**From:** Mark Baldry  
**Sent:** 18 July 2013 11:04  
**To:** planning  
**Subject:** FW: app3/2013/0544 Sherwood York Lane Langho

**From:** Bloomer, David [mailto:David.Bloomer@lancashire.gov.uk]  
**Sent:** 18 July 2013 10:33  
**To:** Mark Baldry  
**Cc:** ENV LHS Customer Service  
**Subject:** app3/2013/0544 Sherwood York Lane Langho

plan

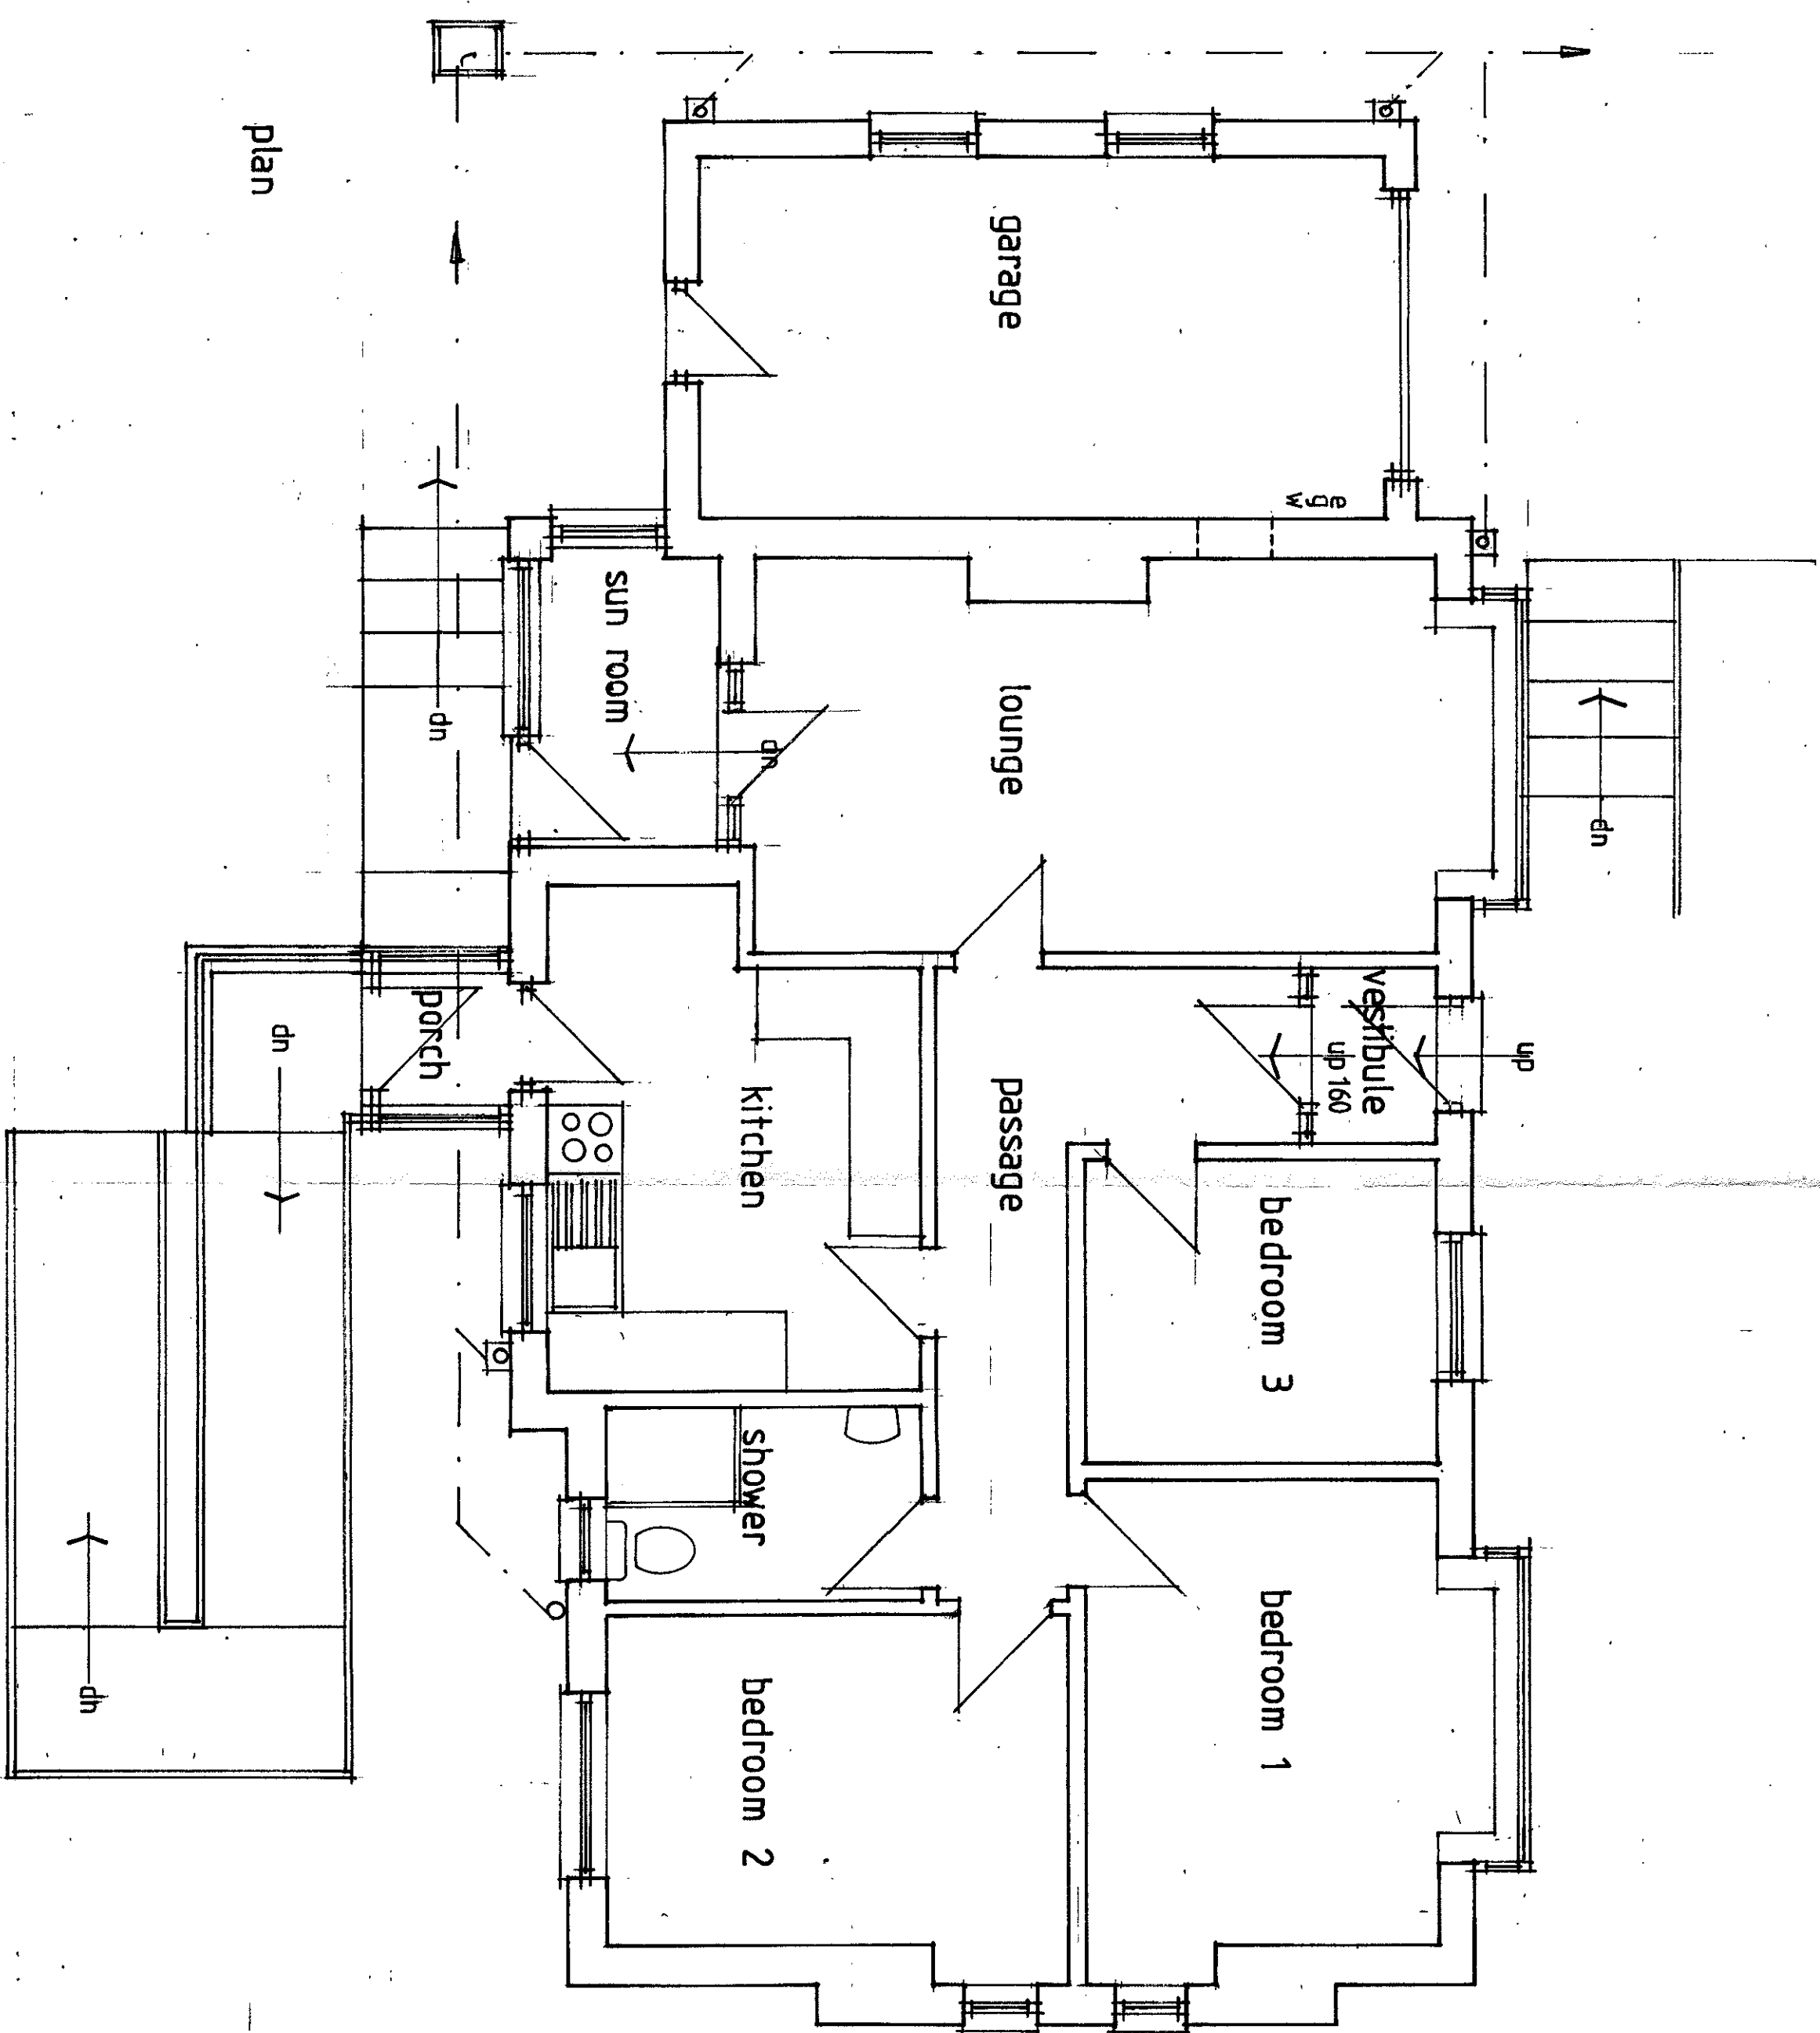
The proposal increases the number of bedrooms from 3 to 4. Currently there are 2 parking spaces ( including the garage). For a 4 bed dwelling a parking provision of 3 spaces would normally be required. However in this instance due to the low density of housing along York Lane there is ample on street parking available, and i would therefore raise no objection to the proposal on highway grounds.
